Your Ref: OWPC13709
Our Ref: AL/23/17/DOC 10-03-2017
Please ask for:
Mr S Davis

Application for approval of matters reserved by condition imposed under AL/47/14/PL relating to condition No. 6 (Landscaping scheme), 7 (Plot boundary fences), 8 (Surface water drainage), 9 (Scheme to improve current site access) & 10 (Lighting)

Aldingbourne Farm Shop Nyton Road Aldingbourne

Tree and Hedge Planting

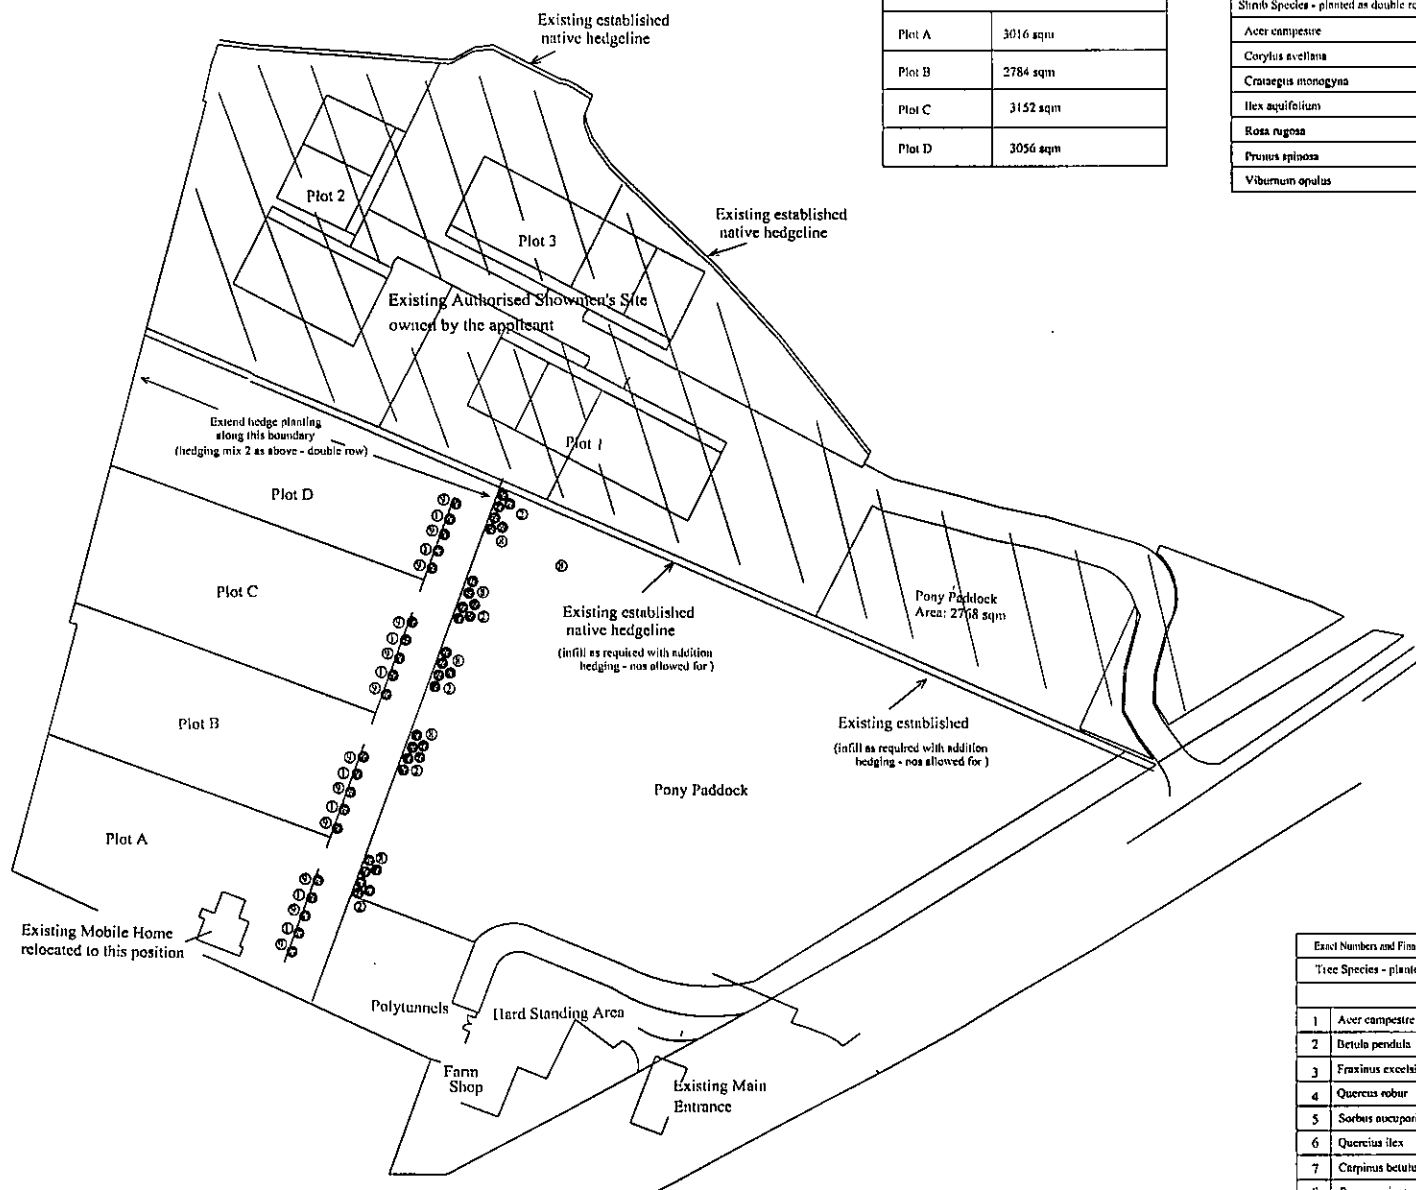
The plan available to view shows very little landscaping and does not include the additional landscaping we have requested along the border to the site that we view from our home. We have requested mature plants to ensure we no longer have to view this site from our home and garden.
